Acceptance of Applications Checklist

Meridian Solar Farm Section 55 Acceptance of Applications Checklist

Section 55(2) Acceptance of applications				
1	Within 28 days (starting day after receipt) The Planning Inspectorate must decide whether or not to accept the application for examination.	Date received	28-day due date	Date of decision
		20 March 2026	17 April 2026	15 April 2026
Section 55(3) – the Planning Inspectorate may only accept an application if it concludes that:				
Planning Inspectorate comments				
Section 55(3)(a) and s55(3)(c): It is an application for an order granting development consent				
2	In accordance with sections(s) 14 to 30 of the Planning Act 2008 (the PA2008), is the development a Nationally Significant Infrastructure Project (NSIP) (or does it form part of an NSIP); and	<p>Yes</p> <p>The proposed development set out in schedule 1 of the Draft DCO (Doc 3.1) includes development falling within the categories in s14 of the PA2008. The</p>

MERIDIAN SOLAR FARM
STREETS, RIGHTS OF WAY AND ACCESS PLAN
REGULATION 5(2)(K)
SECTION B SHEET 3B OF 5

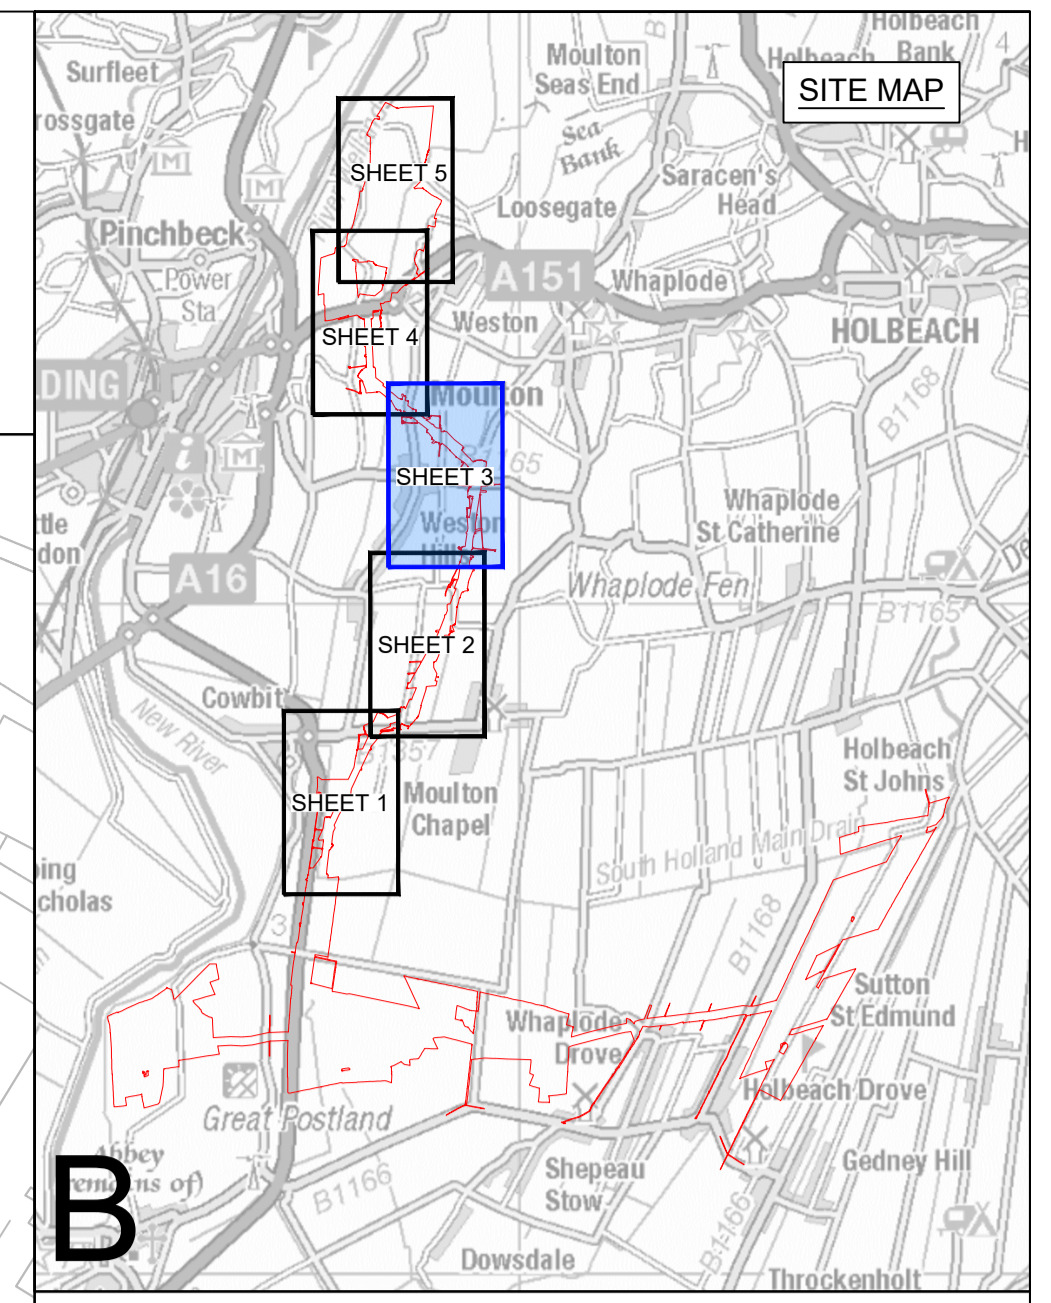
Streets, Rights of Way and Access Plans – Section B Grid Connection (Doc 2.6)

Street names such as Whirl Gate and Austendike Road are missing from sheet no 3B.
